10 June 2026

Council Advice on the Environmental Impact Statement for 200 Aldington Road Industrial Estate - Lot O (SSD-96107226) - 106-228 Aldington Road, Kemps Creek

Council Advice on the Modification Report for 200 Aldington Road Industrial Estate - Lot O (SSD-10479-Mod-7) - 106-228 Aldington Road, Kemps Creek

1 SIGNAGE PLAN 1 : 2000

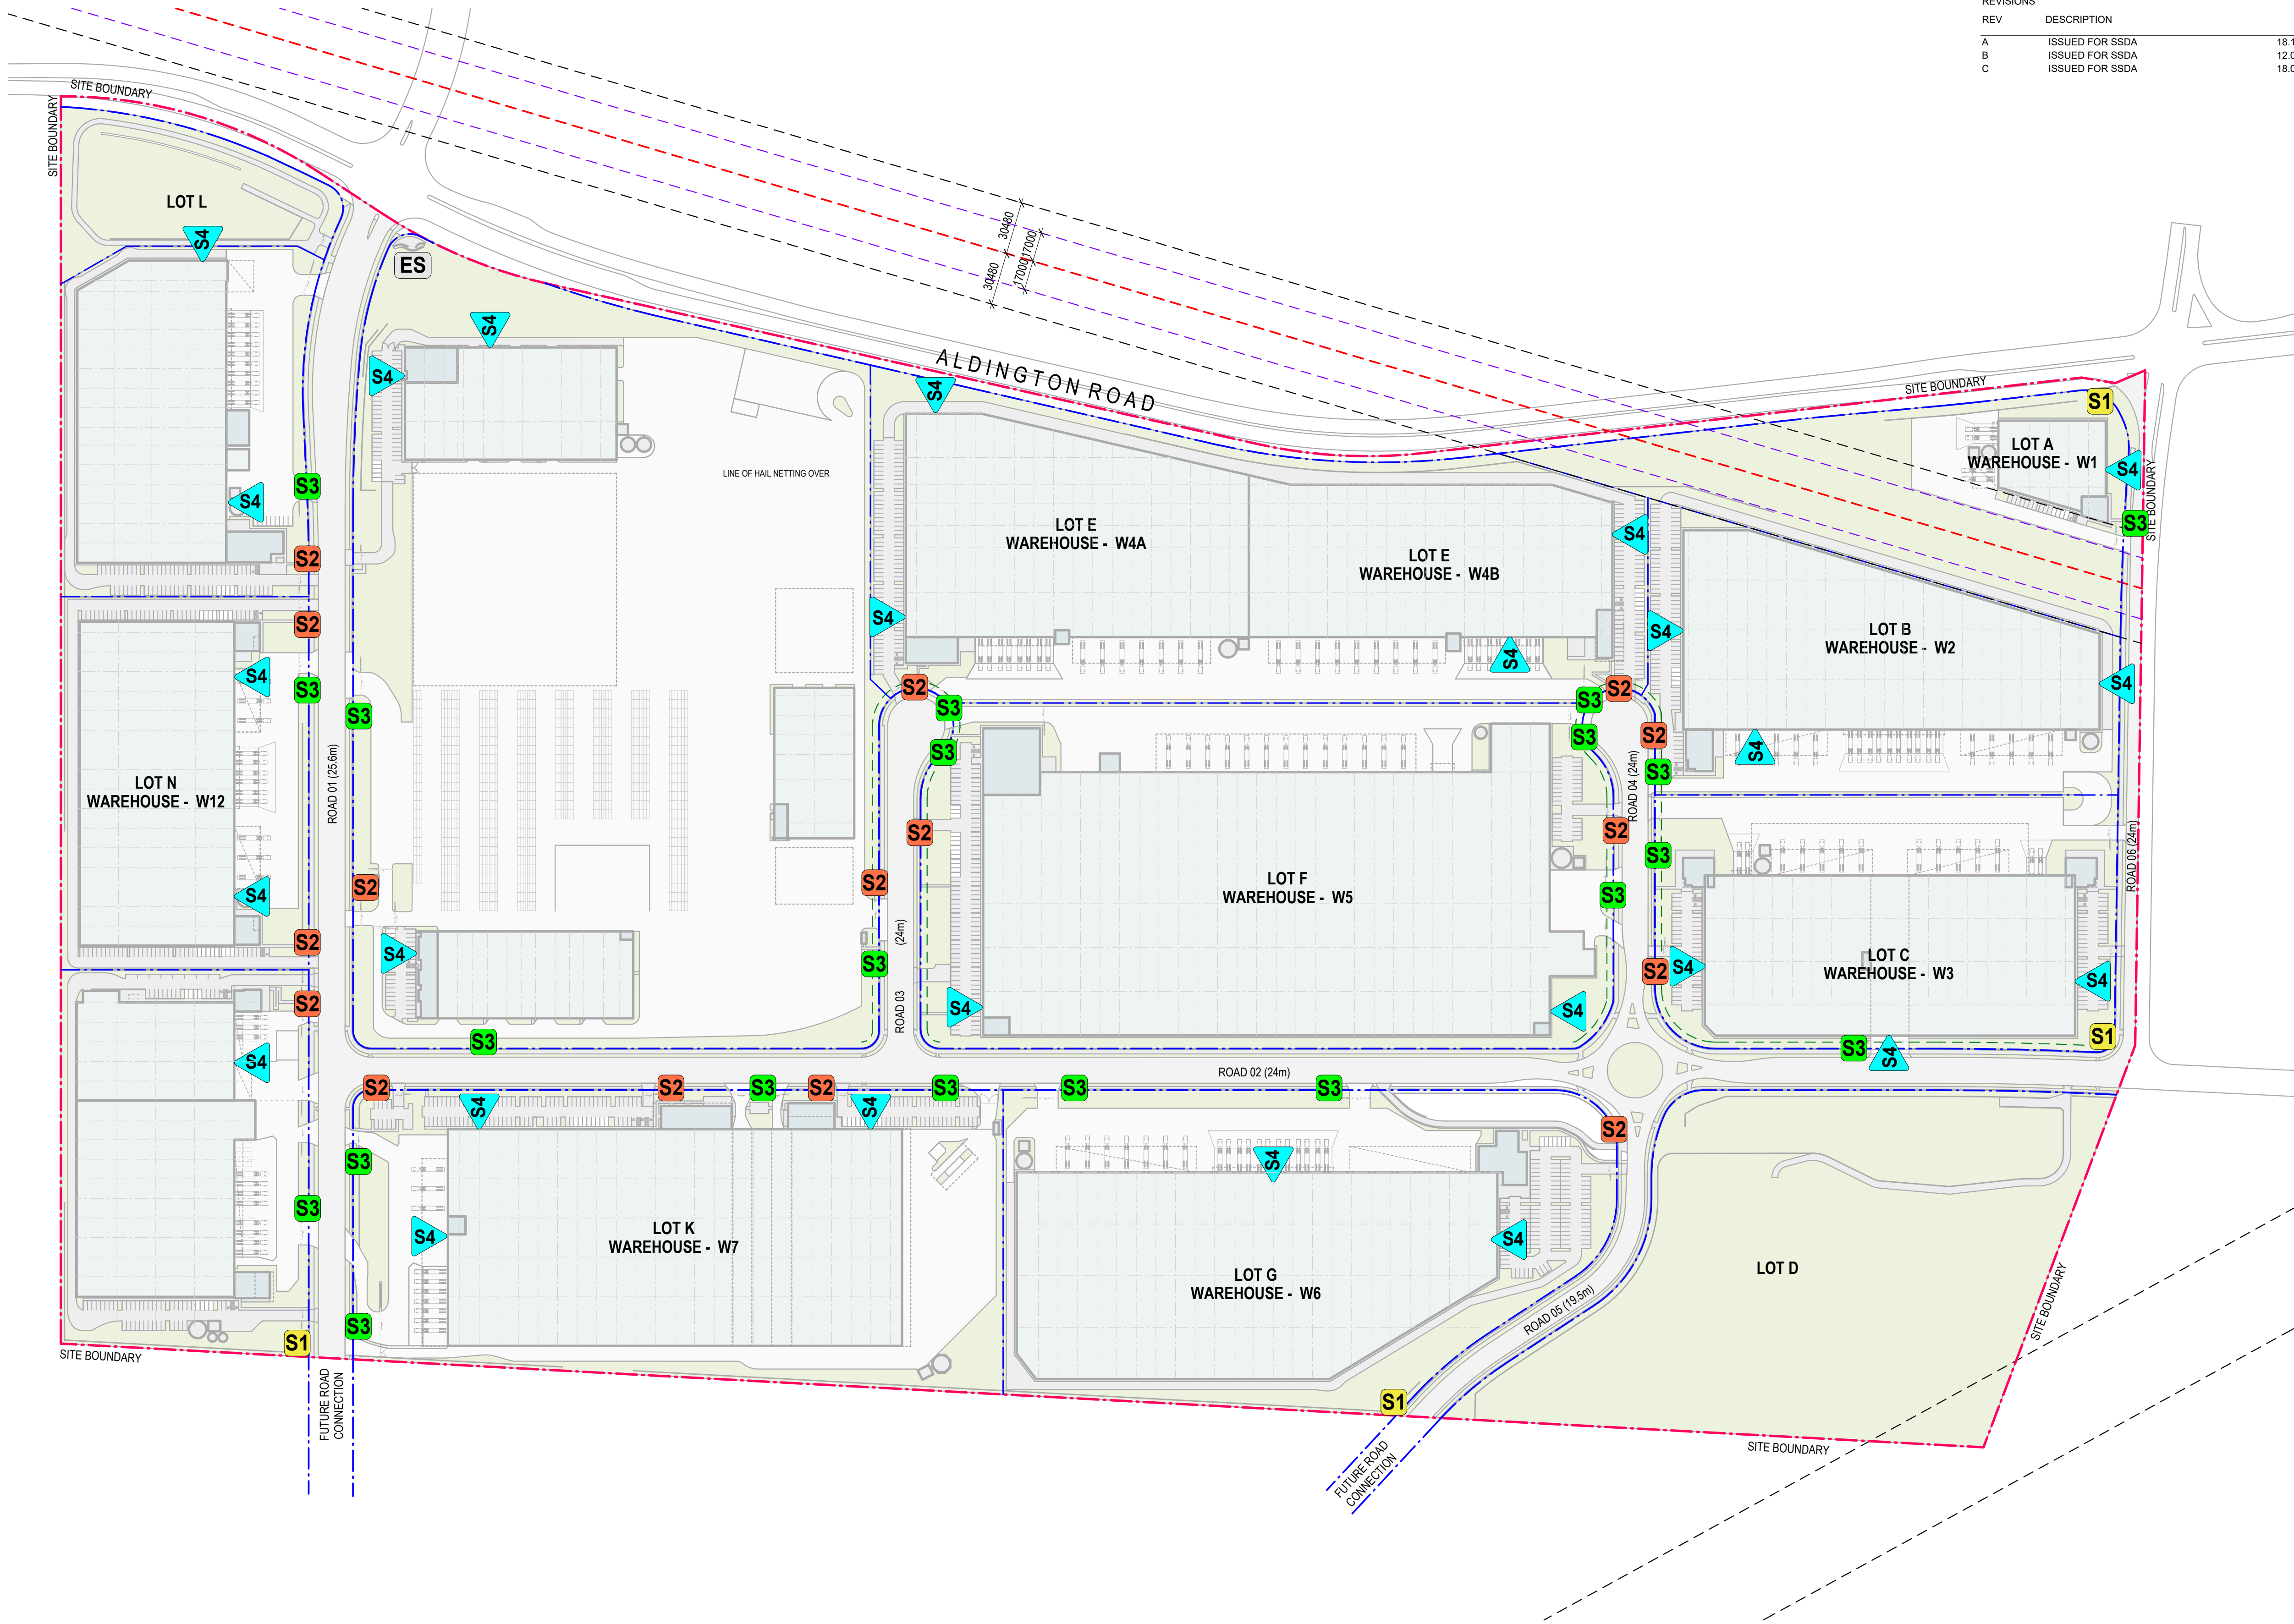
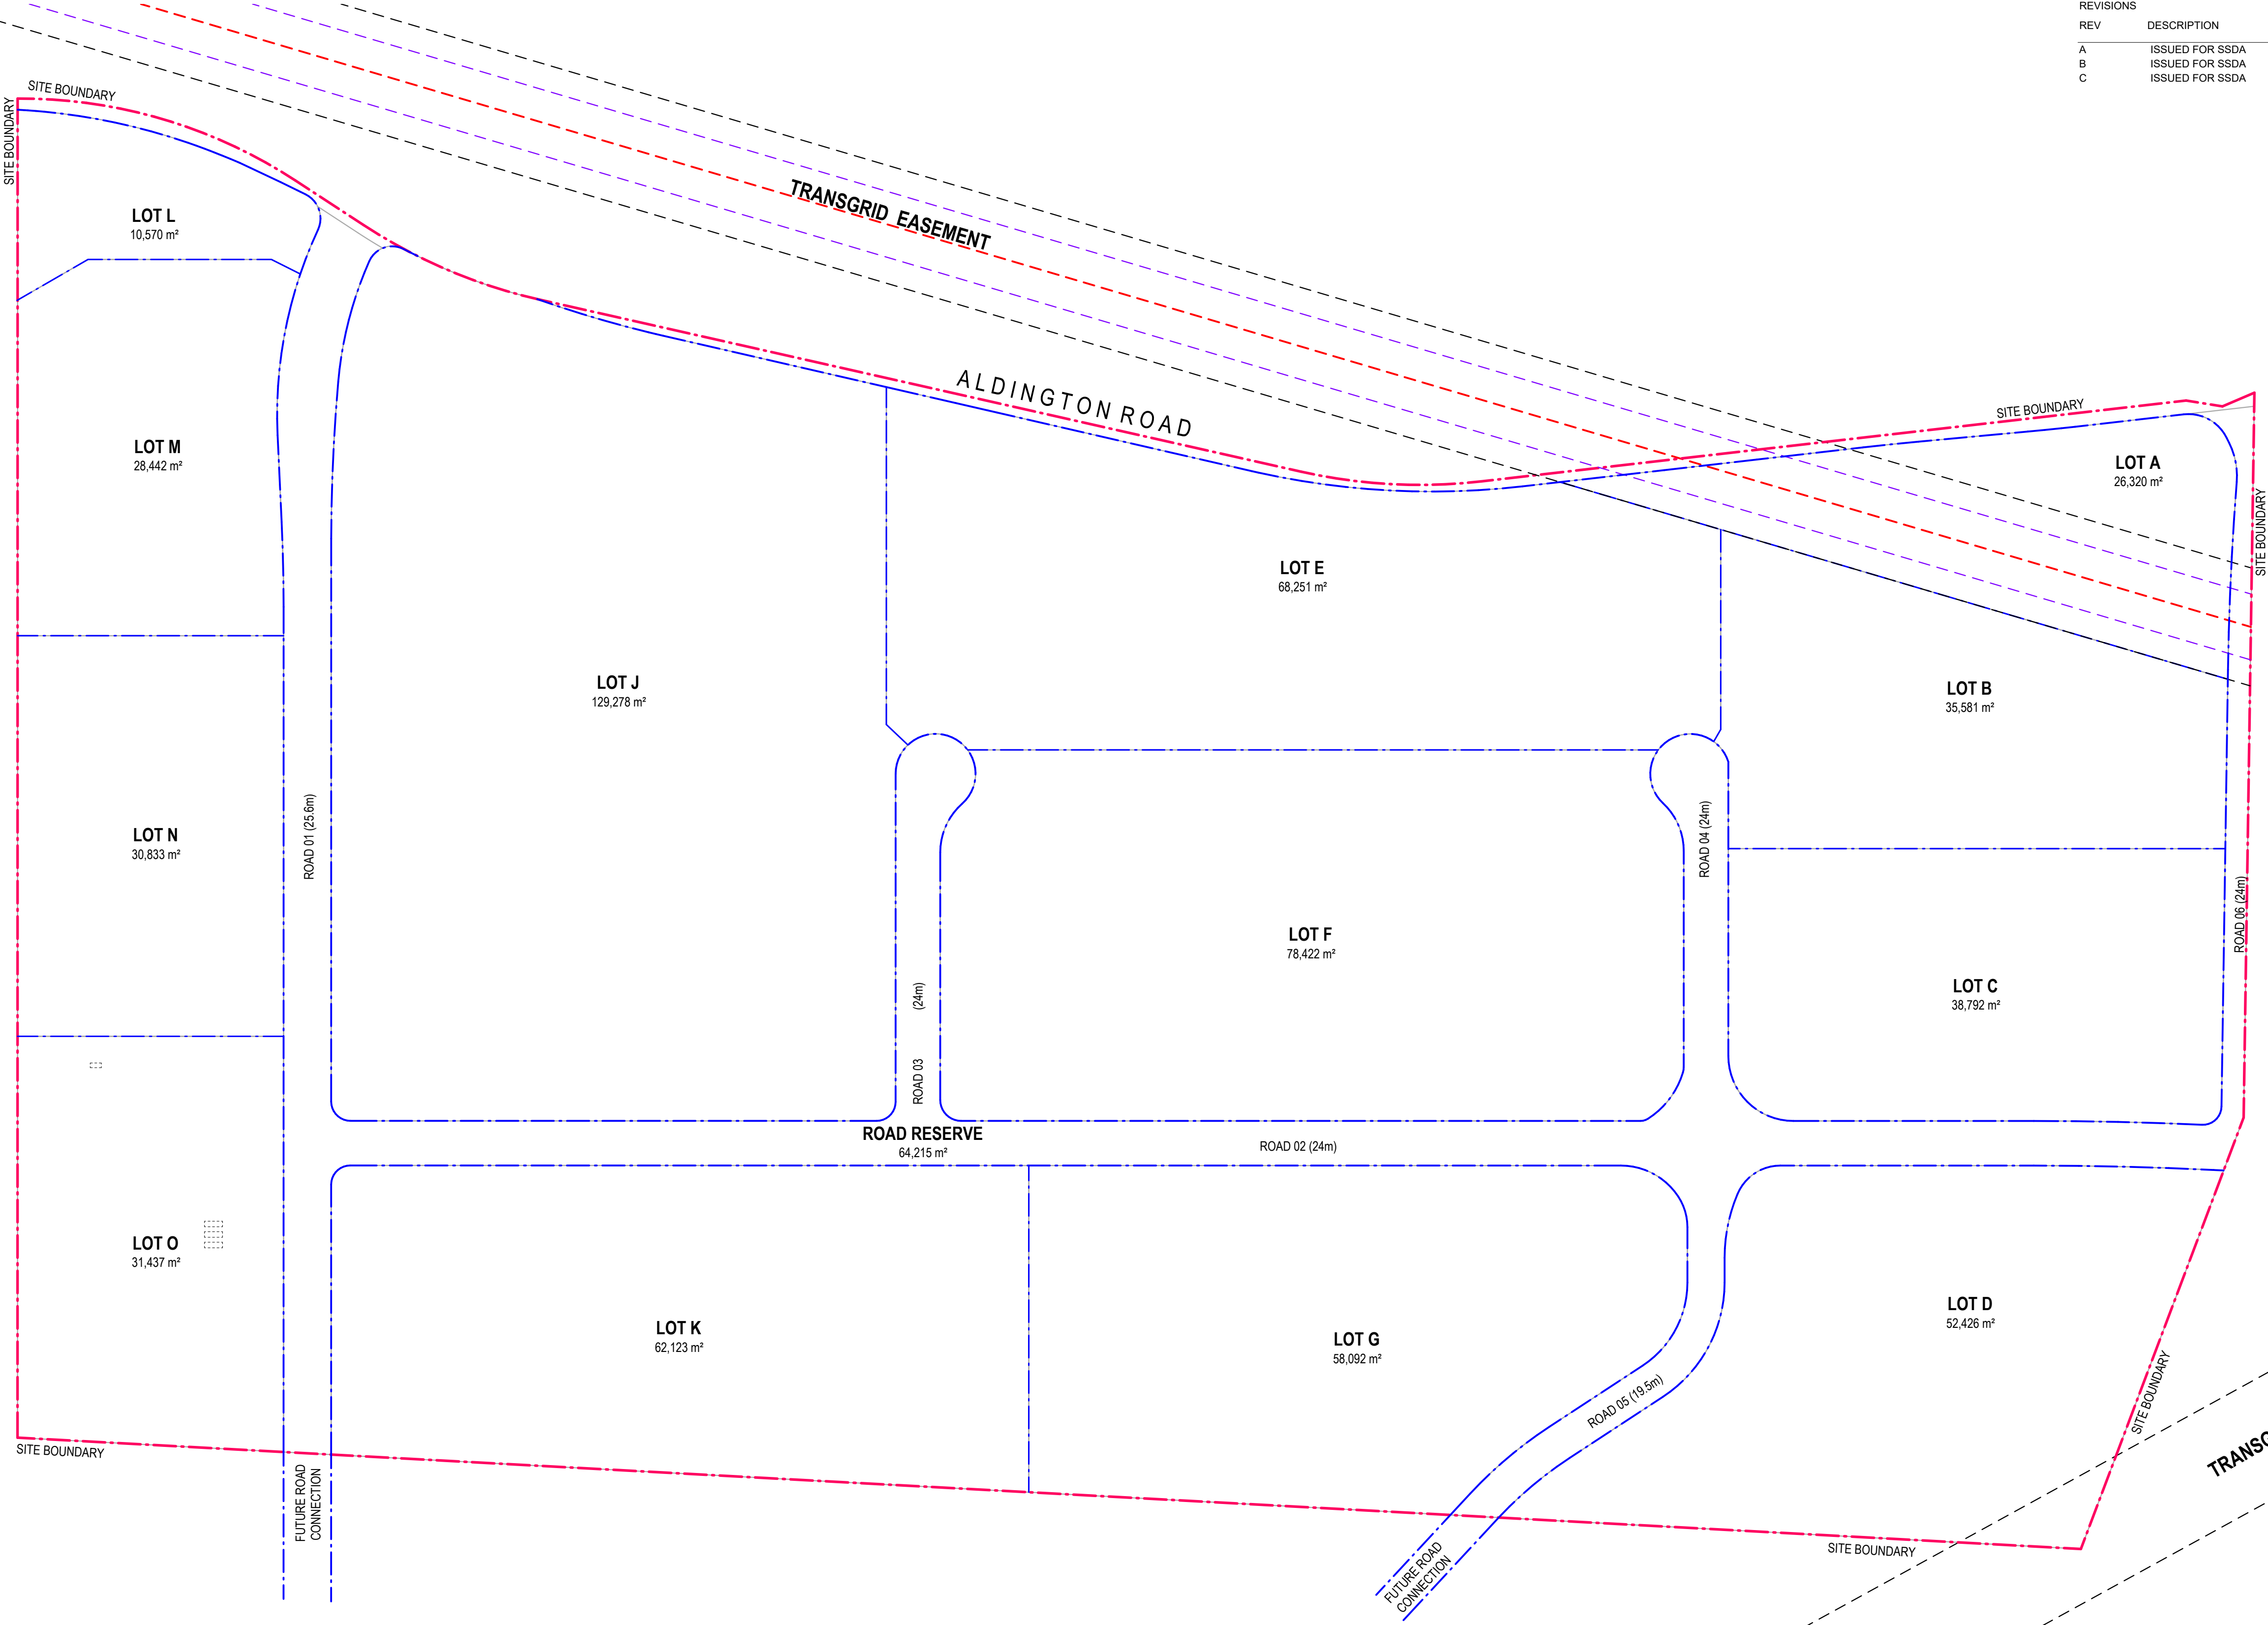
- The Final Road Design Plan shall consider the location of the S2 sign for warehouse 2.
- The Department is to consider legal access for the use of the temporary bulb (i.e. right of carriageway).
